Ms. Lauren Anderson
Planner
City of Mercer Island, Community Planning and Development

June 15, 2020

Re: Permit No. 2001-188 (building) and No. Sub 18-005 (short plat)
4270 East Mercer Way

Thank you for giving us the opportunity to respond to the comment letter dated June 10, 2020. Below please find the original text and our responses:

Site Plan

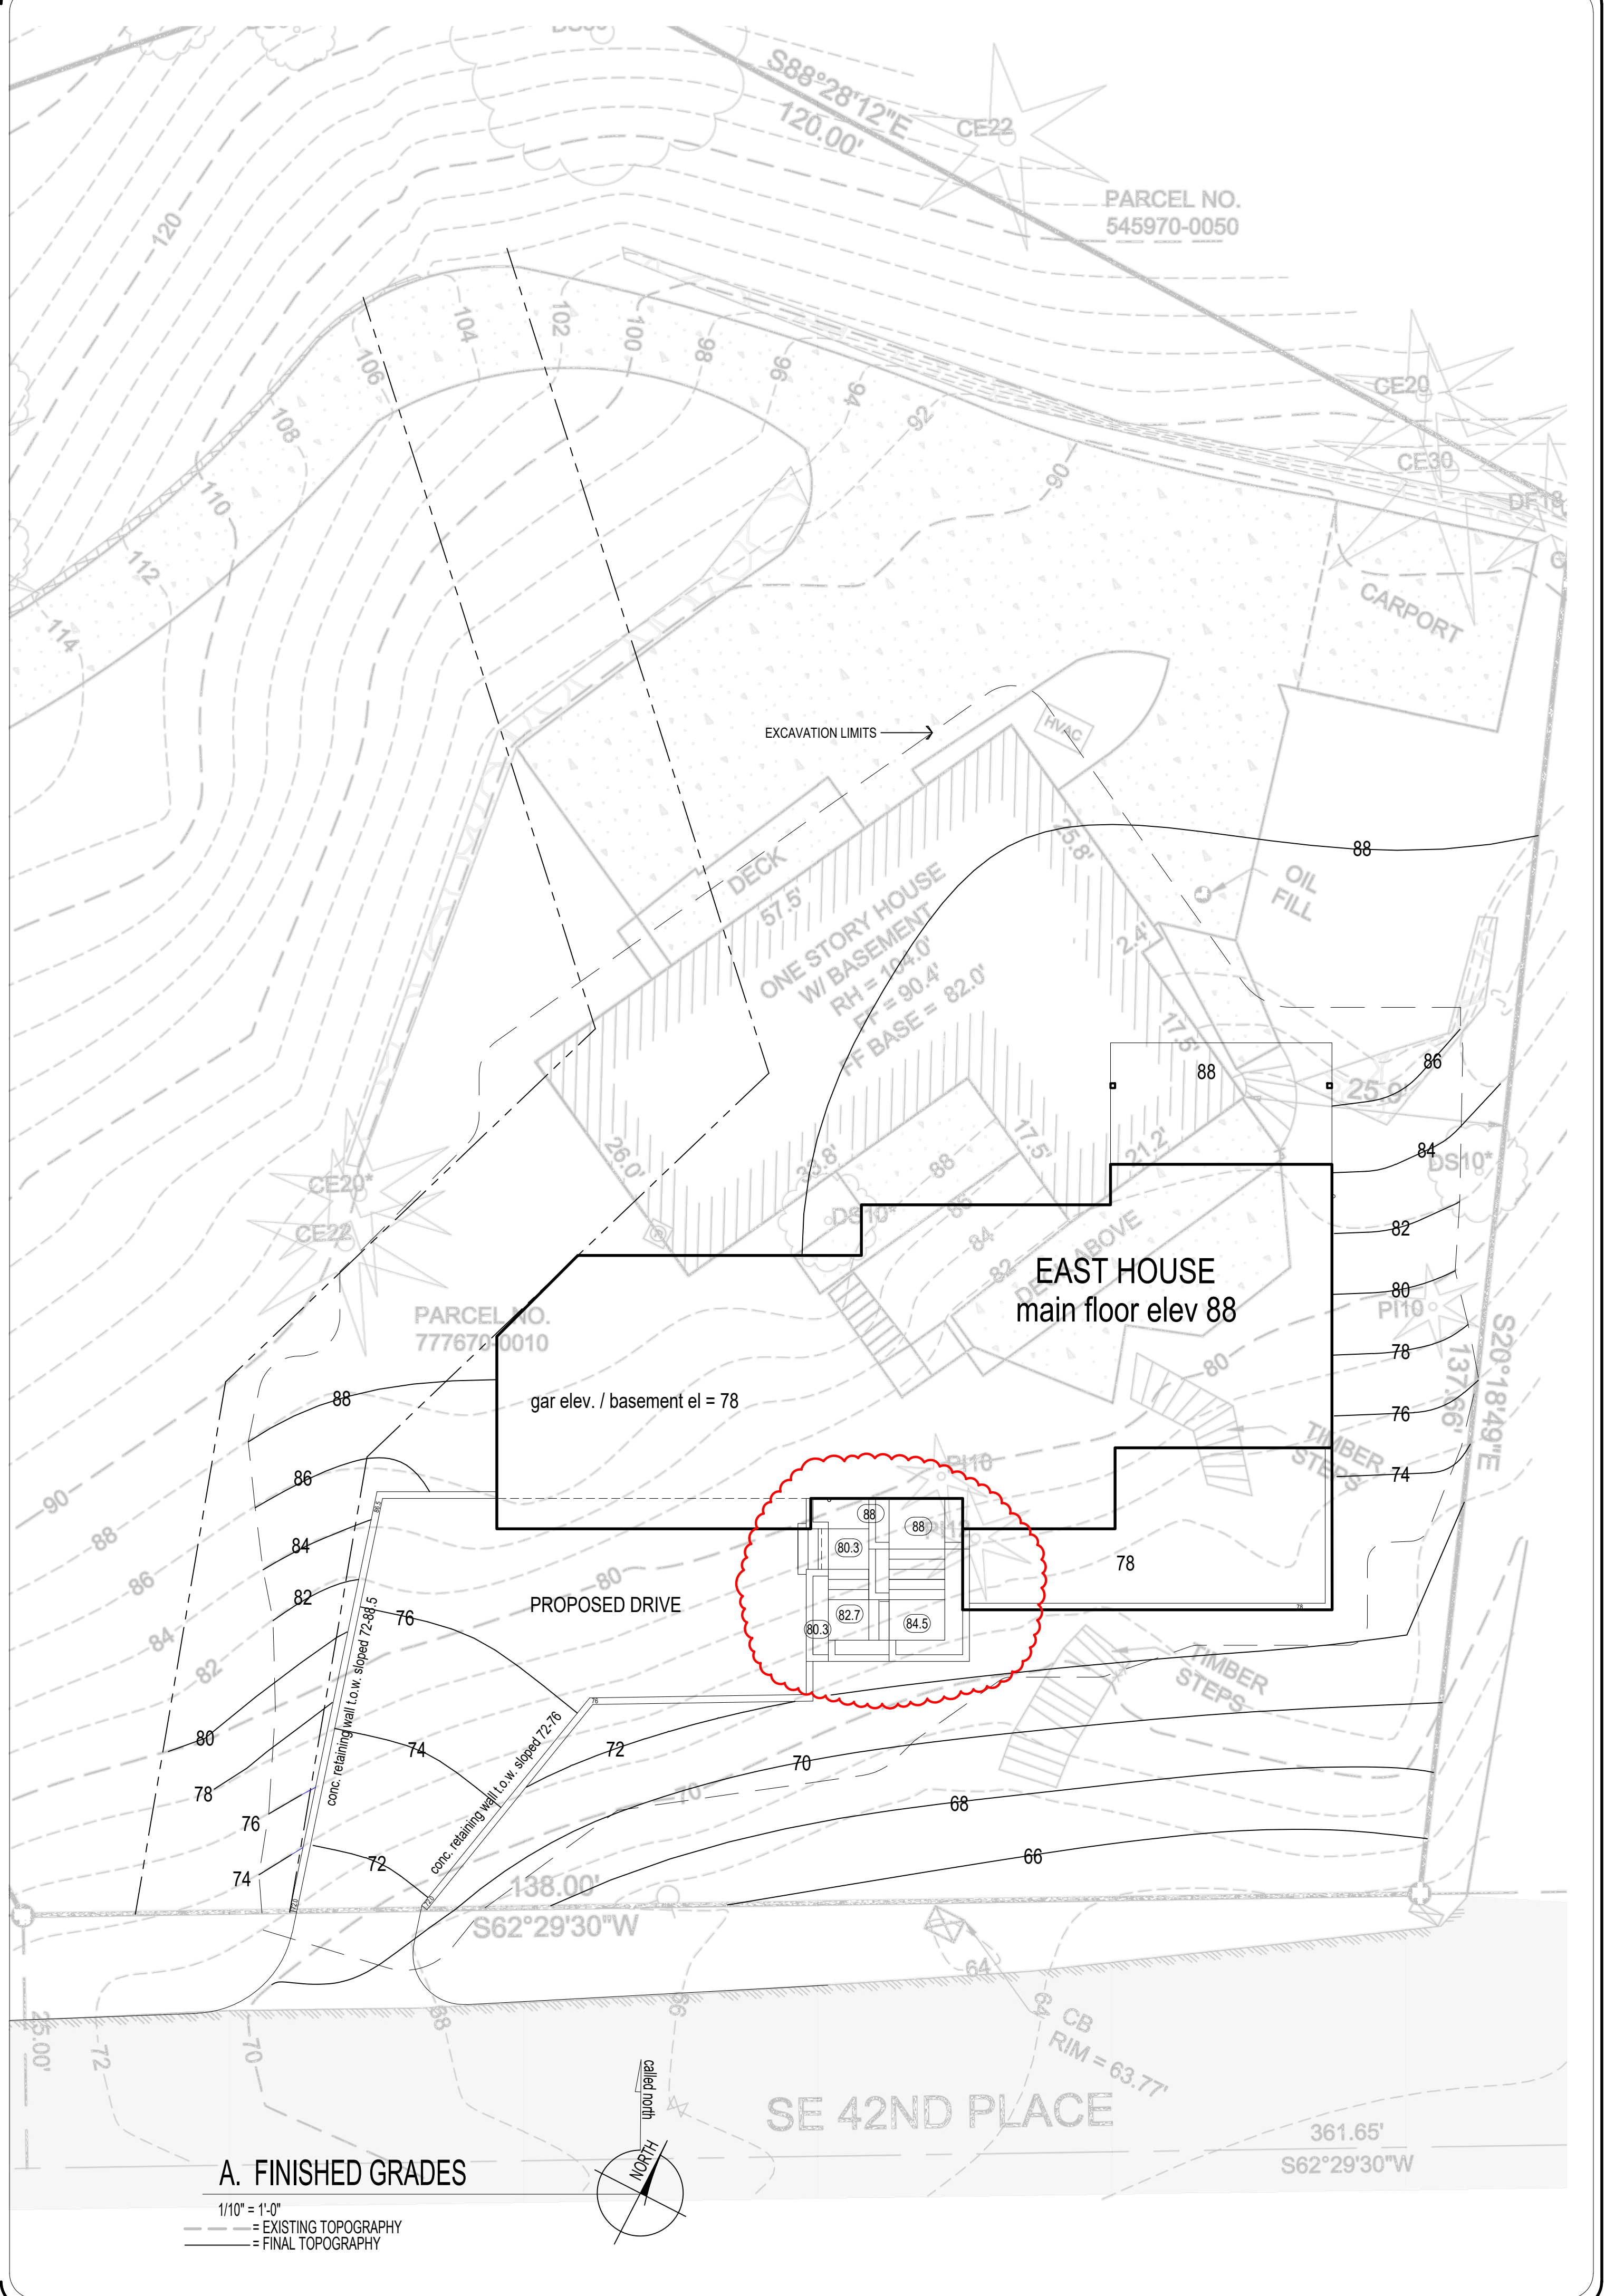
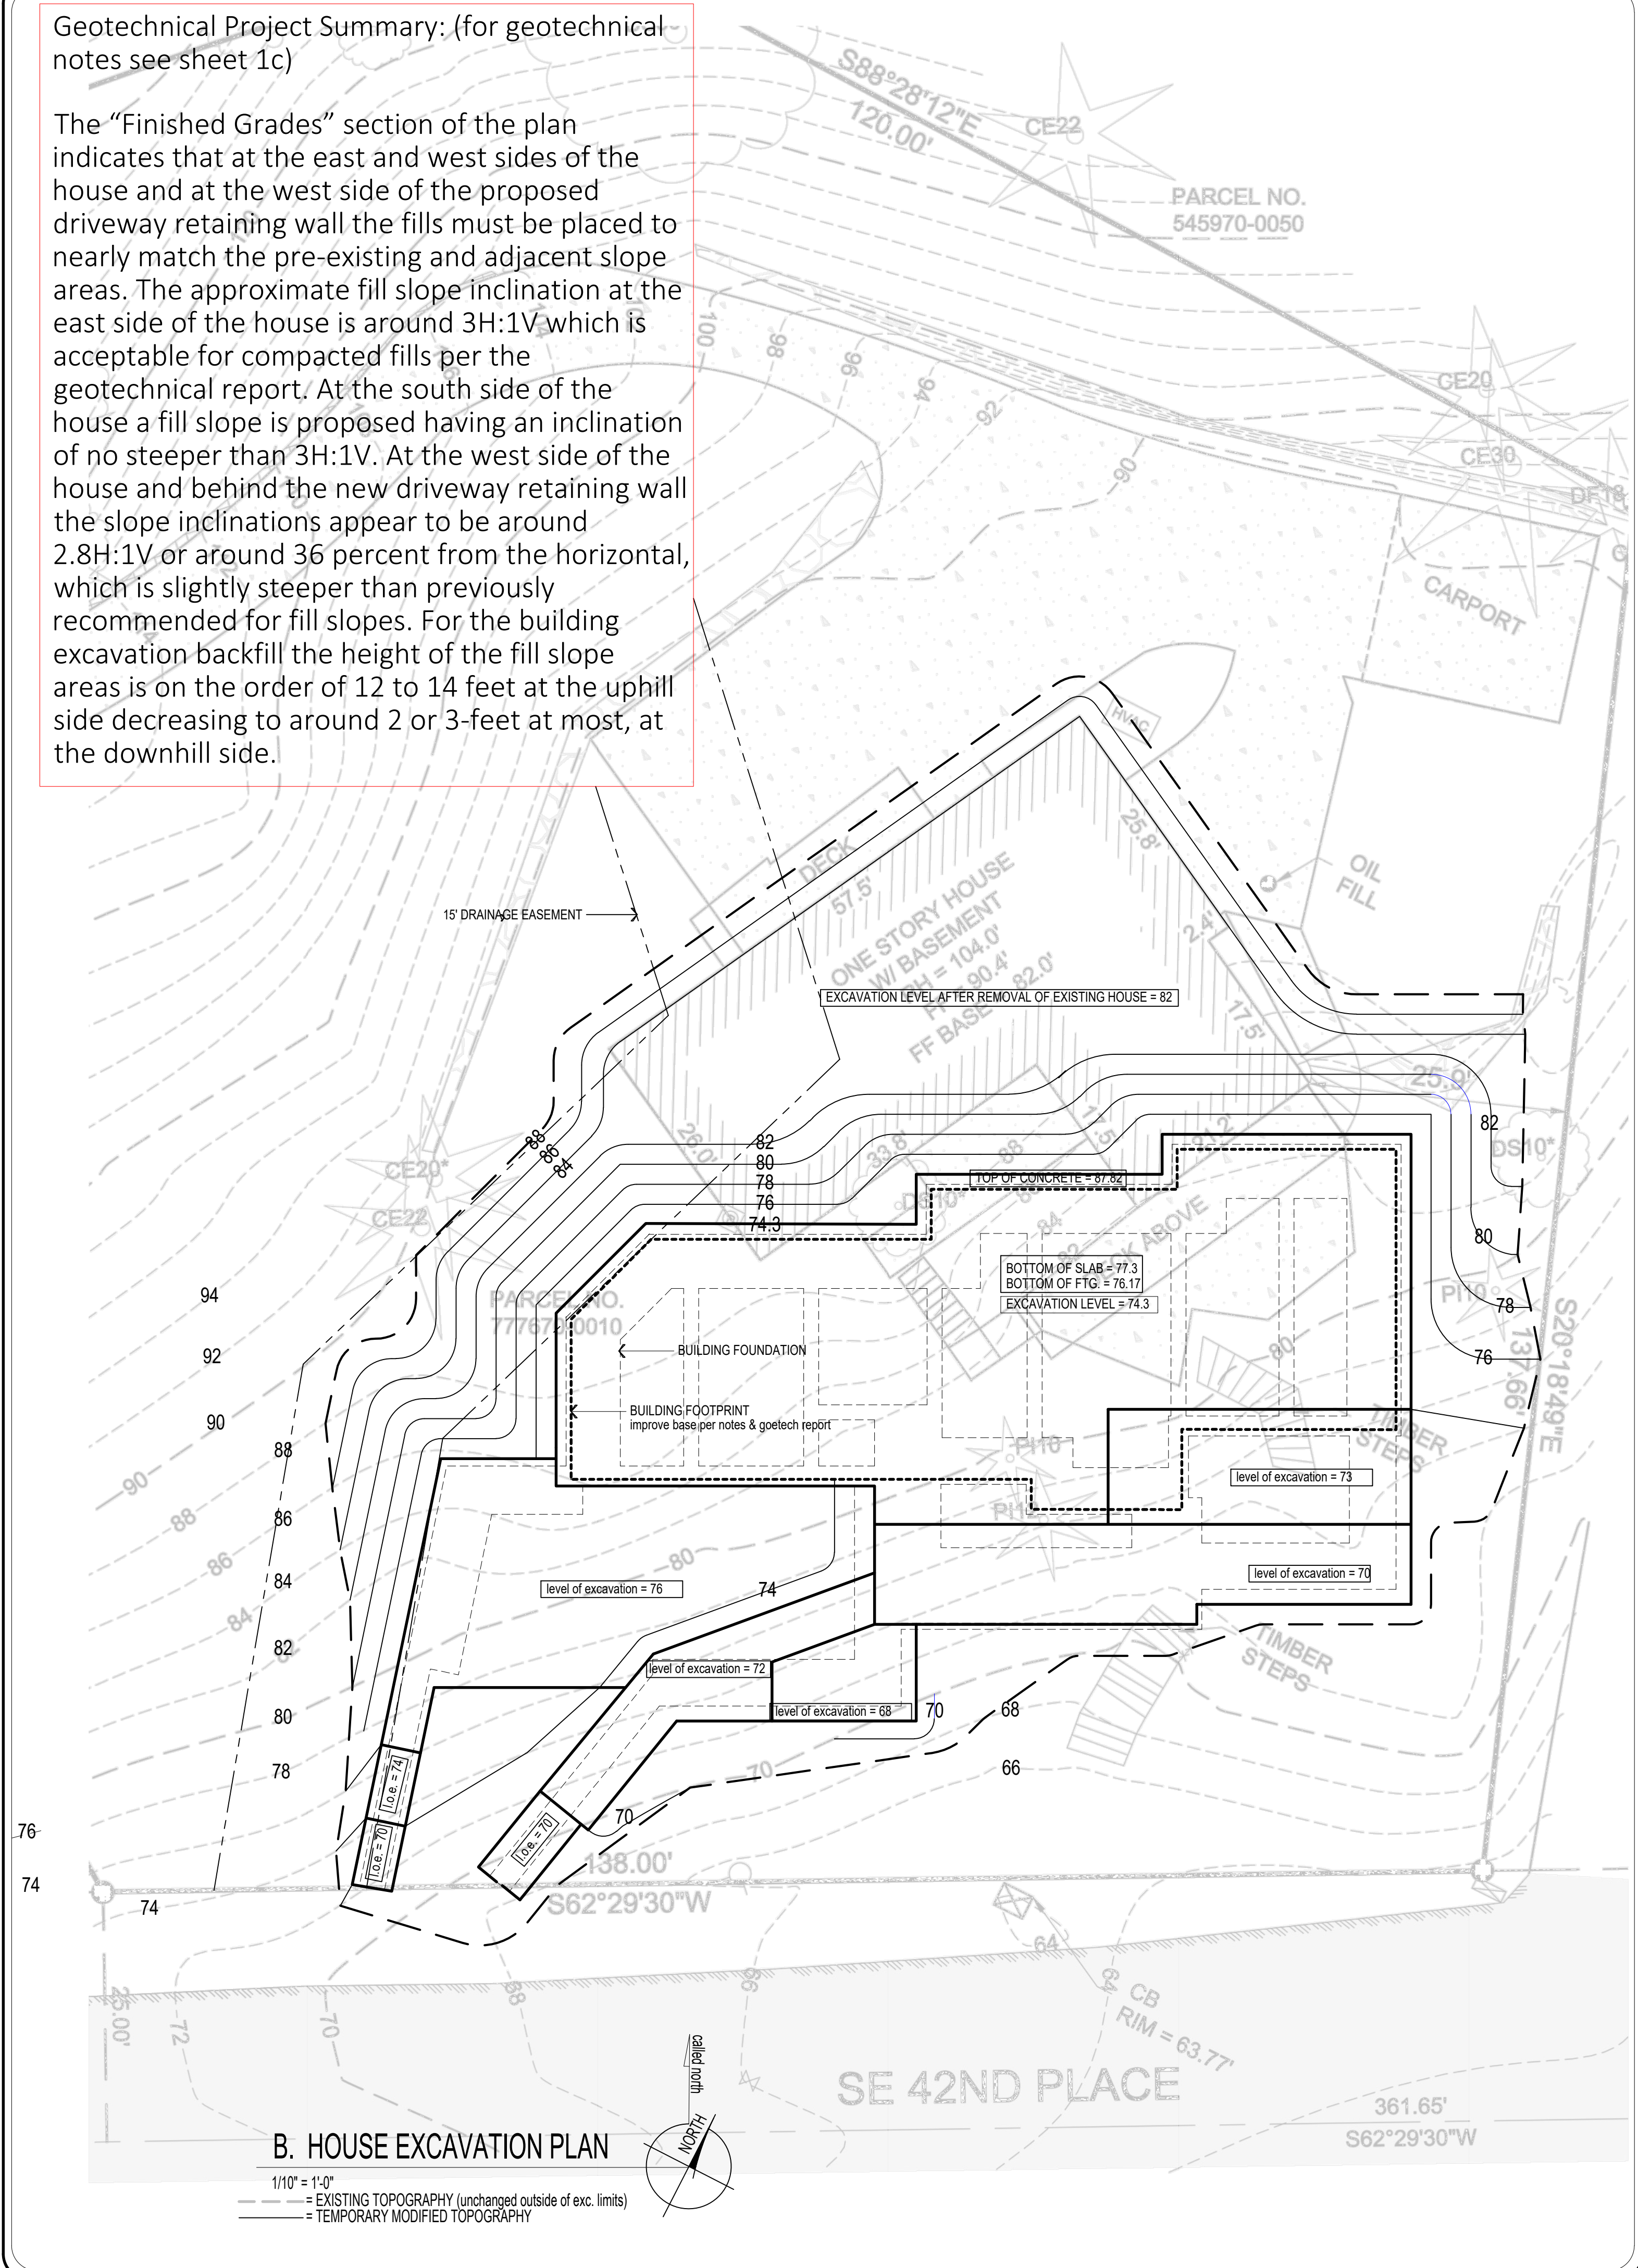
First, there does not appear to be any survey of the existing storm drain line running from East Mercer Way to SE 42nd Place. As we understand it, such a survey has been requested by the City and is required by MICC 19.08.020.C. There is a proposed storm drain easement on the site plan (sheet 1a) for the building permit, but this does not appear to reflect the path of the existing storm drain.

Second, the proposed storm drain line shown on sheet 1a of the building permit meanders, traveling southeast, then southwest, and then again southeast from East Mercer Way to SE 42nd Place, rather than proceeding in a straight line. As we understand it, storm drain lines should proceed in a straight line to allow ease of access for maintenance and repair, as well as to minimize disruption to a critical area in keeping with MICC 19.07.010 and related requirements. In keeping with MICC 19.09.100, moreover, we believe that the storm drain line should be required to track the demising line (discussed in the next paragraph).

First, we are concerned that the proposed building will not comply with RDS requirements for a side yard. Under MICC 19.02.020.C.1.c.iii(b), we believe that the minimum side yard depth for the proposed building is 10 feet, as shown on the site plan (sheet 1a). Also as shown on the site plan, the proposed house improperly encroaches into the side yard. We believe this is not appropriate.

Response: The primary line and critical points have been surveyed and shows on the latest survey (see SUB 18-005 Sub 3). The existing sub-standard lines (4" diameter), without easements, will be abandoned and a new-engineered system with a 15' maintenance easement will be installed. The new line abandons these insufficient components and a path more conducive to maintaining the upper tree grove and slope have been proposed.

Response: The storm drainage system has been design to avoid unnecessary disturbance within the root zones of trees in the upper grove and minimize the extent on a steep slope. For ease of maintenance two catch basins are located on the property within the easement and the lines running between them are straight.

The storm system was designed considering the terrain and vegetation to minimize impacts. There is no requirement that the drainage line or easement follows the property line. Since the area where there is remaining property between the easement and property line are well within the setbacks and outside of building pads of the proposed short plat, access is improved over the situation of the drainage line and property line being identical.

Response: Presumably, this is in regard to the Western line, since the Eastern line has a 8'-8.3/8" setback and the building is 11'-0" away from the line. In any event, MICC allows for variable setbacks based on the height of the structure above existing or final grade. Since the structure height at this point is below 25', the setback requirement is 7'-6".
